A57 Link Roads

TR010034

8.3 DRAFT STATEMENT OF COMMON GROUND WITH HIGH PEAK BOROUGH COUNCIL

Version	Date	Status of Version
Rev 2.0	January 2022	Deadline 2
Rev 1.0	June 2021	DCO Application

© OpenStreetMap (and) contributors. CC-BY-SA
 Contains OS data © Crown Copyright and database right

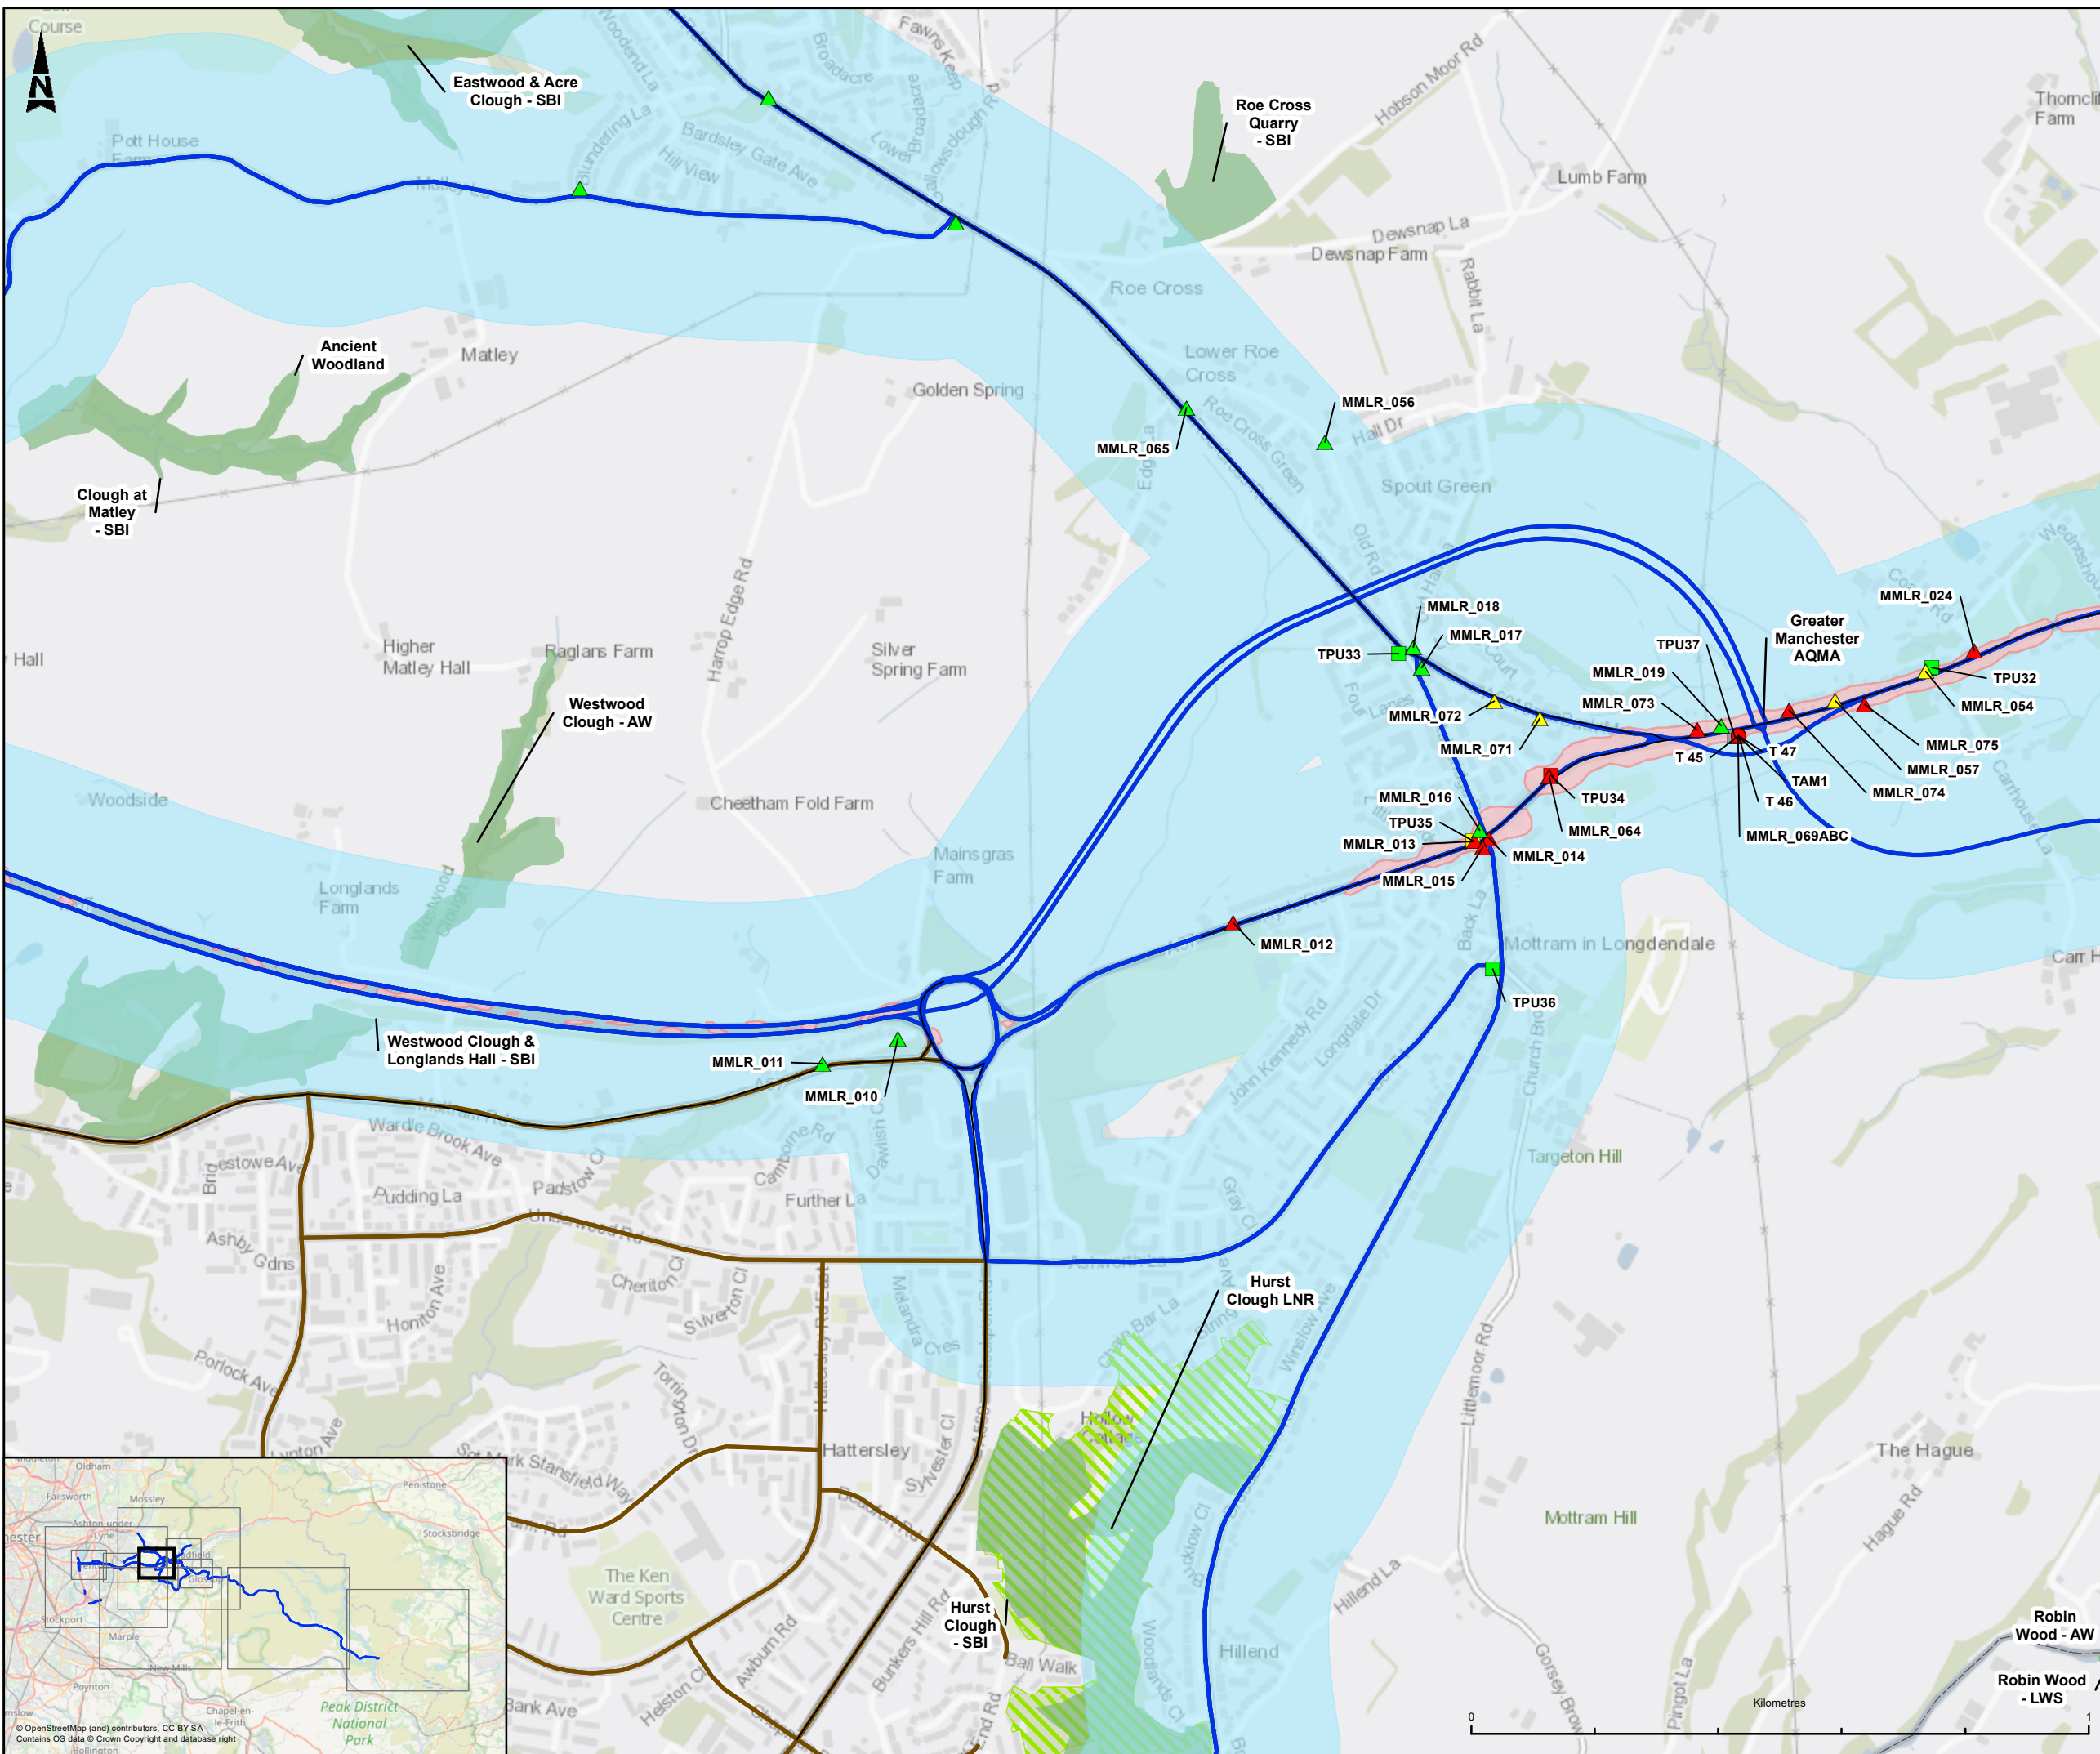
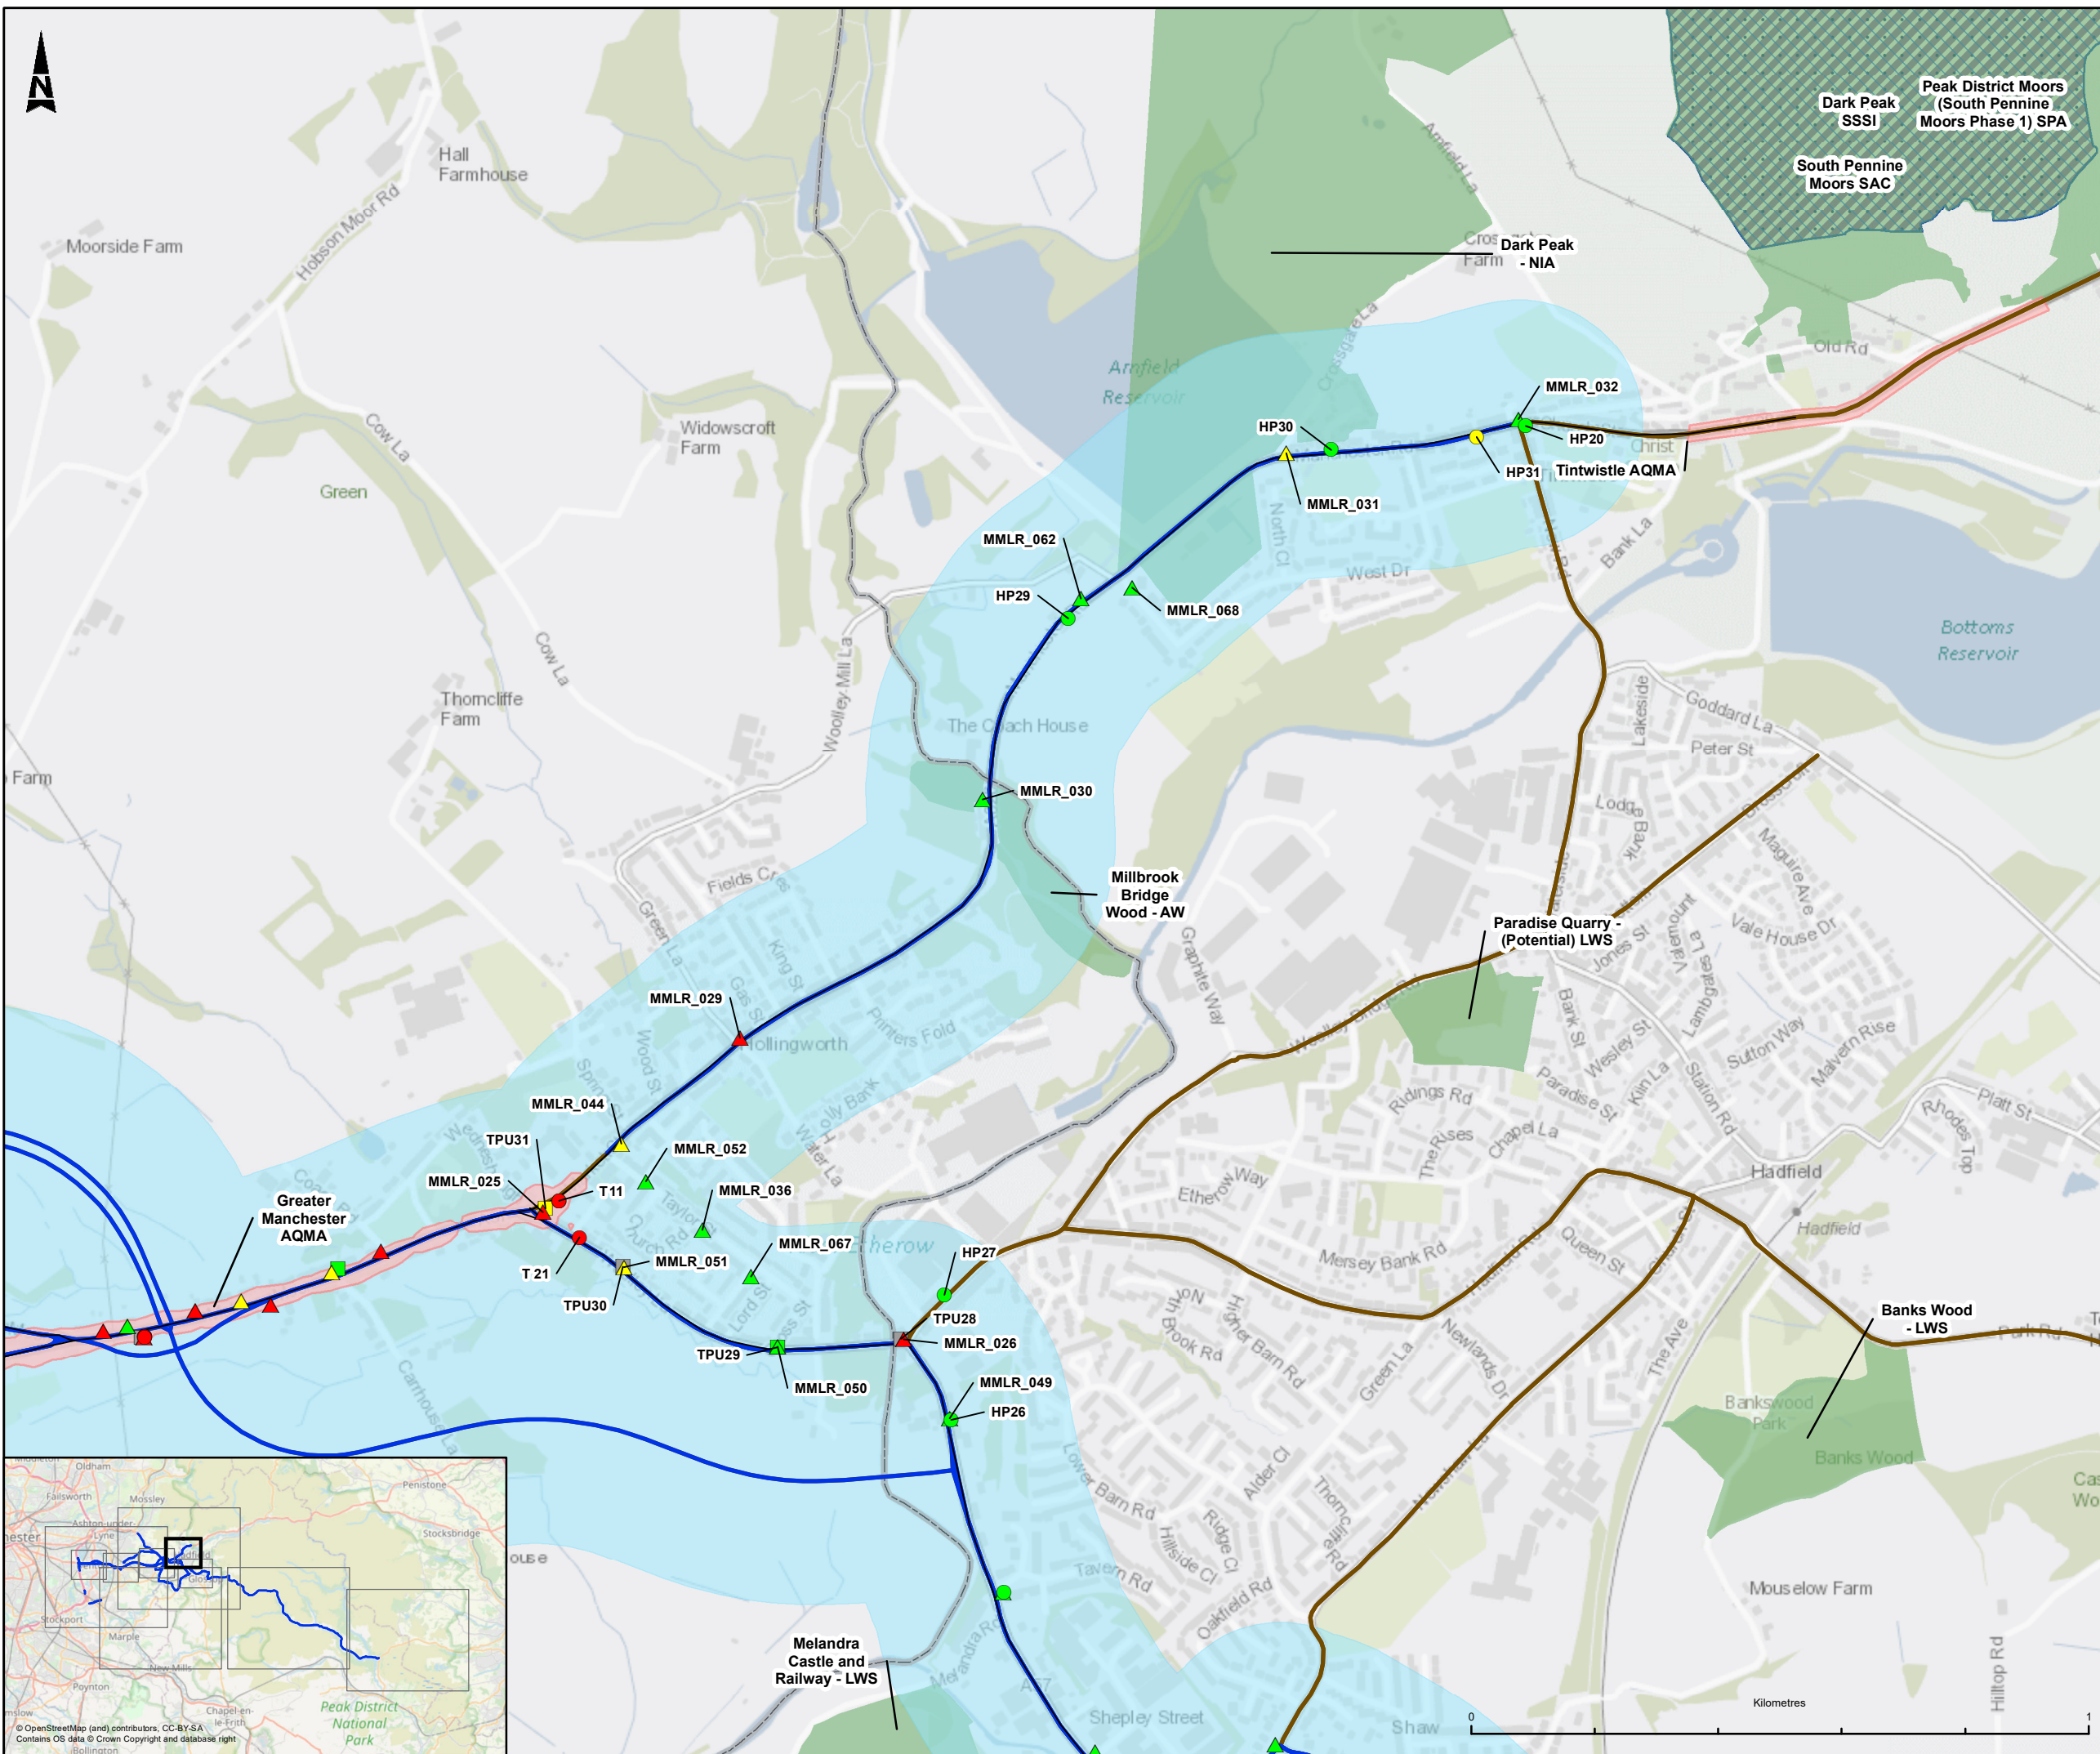
SoCG Ref. Number	Relevant examination document	Relevant Issue	HPBC Comment	National Highways response	Status
3. Environmental Statement and DCO Requirements					
3.1	Environmental Statement (ES)	Air Quality Methodology	The Consultee stated that air quality is a major concern. Since the last public consultation on the scheme in 2018, HPBC has designated Air Quality Management Areas (AQMAs) on sections of the A628 in Tintwistle and the A57	The Applicant's air quality assessment (in the ES [APP-061] has taken into consideration the AQMA designated since 2018 in Tintwistle and Dinting Vale. The air quality assessment has been	Under Discussion

SoCG Ref. Number	Relevant examination document	Relevant Issue	HPBC Comment	National Highways response	Status
	[APP-061]	AQMAs	at Dinting. Detailed assessment is required.	undertaken in accordance with DMRB LA105 with the air quality study area determined on the basis of traffic change criteria given this guidance.

3.2	Environmental Statement (ES) [APP-061]	Air Quality Methodology Dinting Vale	The Consultee questioned the air quality results at Dinting Vale.	The air quality assessment has been undertaken in accordance with DMRB LA105 with the air quality study area determined on the basis of traffic change criteria given this guidance. A detailed assessment of air quality has been undertaken for all areas where traffic changes are expected, which includes the Dinting Vale area. Full results will be reported in the Environmental Statement [APP-061].	Under Discussion
